Application Ref:	2025/0349			 Ribble Valley Borough Council <hr/> www.ribblevalley.gov.uk
Date Inspected:	13/06/2025	Site Notice:	13/06/2025	
Officer:	EP			
DELEGATED ITEM FILE REPORT:				APPROVAL

Development Description:	Proposed single storey side extension and internal alterations (pursuant to variation of condition 2 (plans) on permission 3/2024/1028).
Site Address/Location:	Apple Tree Cottage, 4 Orchard Cottages, Branch Road, Waddington BB7 3HR.

Proposed Side Elevation
Scale (1 : 100)

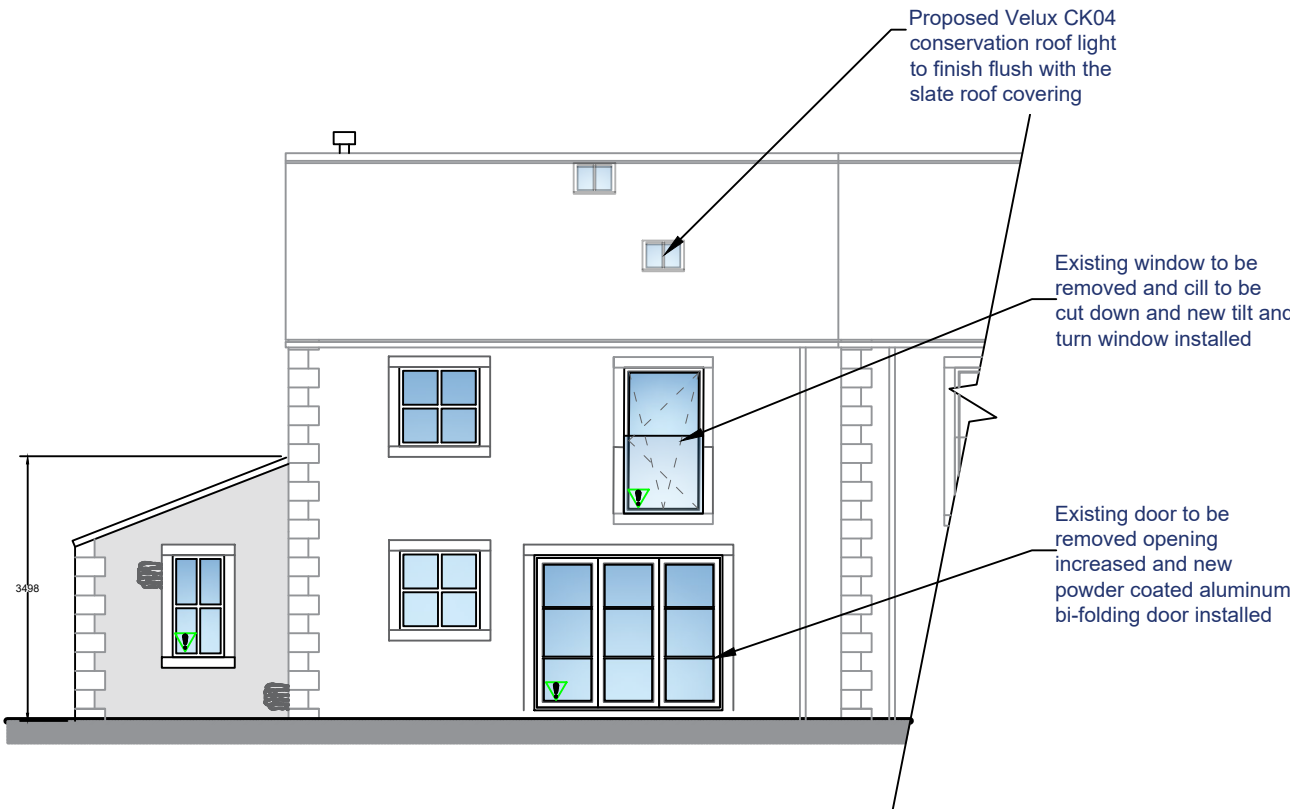
In respect to the proposed alteration to the first-floor window in the side elevation, the size alteration is marginal and will not have a significant impact on the character of the property. The window size is reflective of the remainder of the windows on the property and will therefore integrate sufficiently.

Proposed Site Plan
Scale (1 : 500)

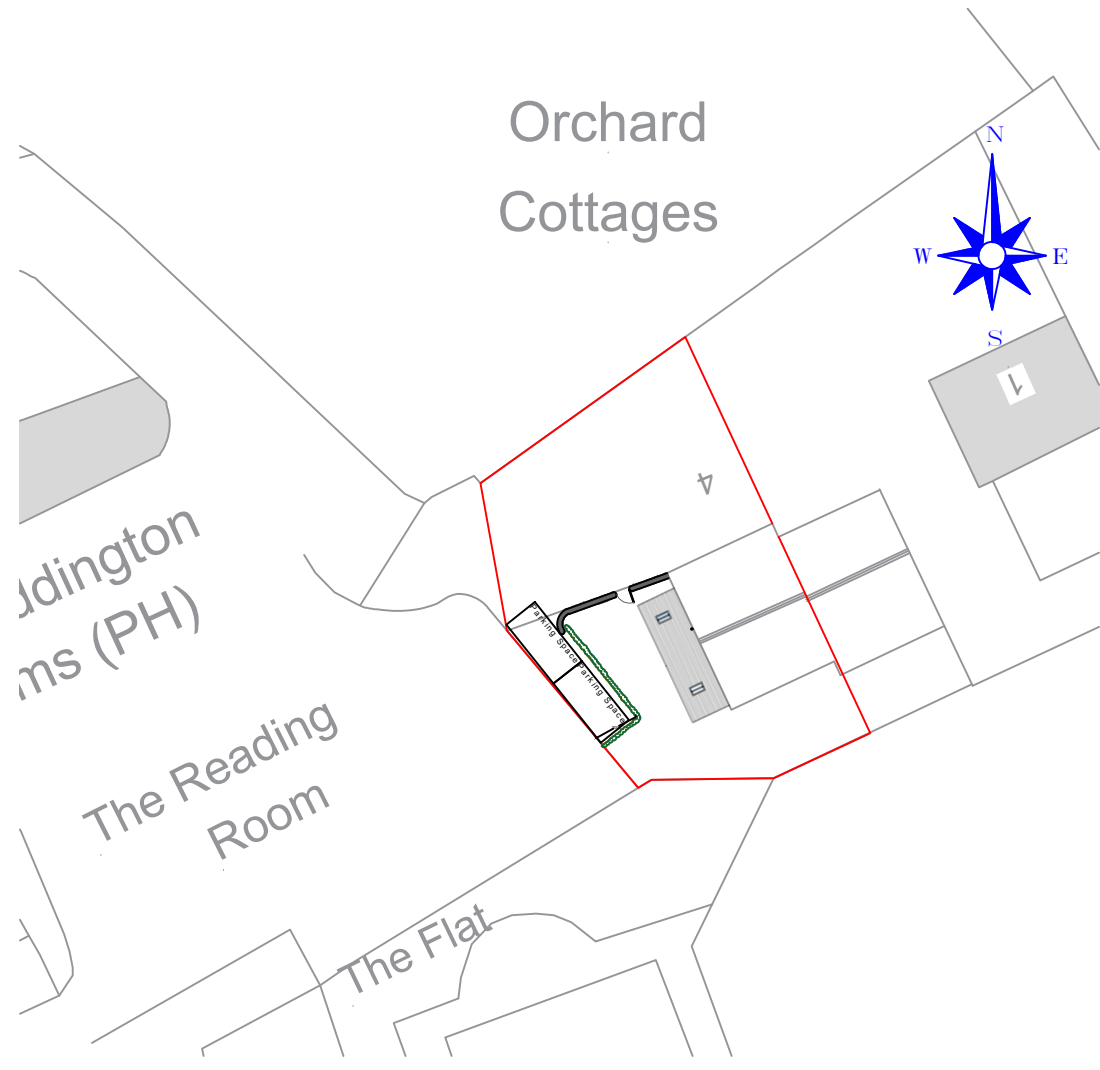
The proposed parking area has been altered so that both spaces sit parallel to the western side boundary of the application site. This is not considered to have an adverse impact from a visual perspective. The

proposed stone wall boundary treatment to the front of the curtilage is considered in keeping with the surrounding area.

LCC Highways have been consulted in relation to the proposal and raise no objection subject to conditions relating to the implementation of the proposed parking spaces. There have been no issues raised with the amended parking arrangement, and it is considered to comply with parking standards.
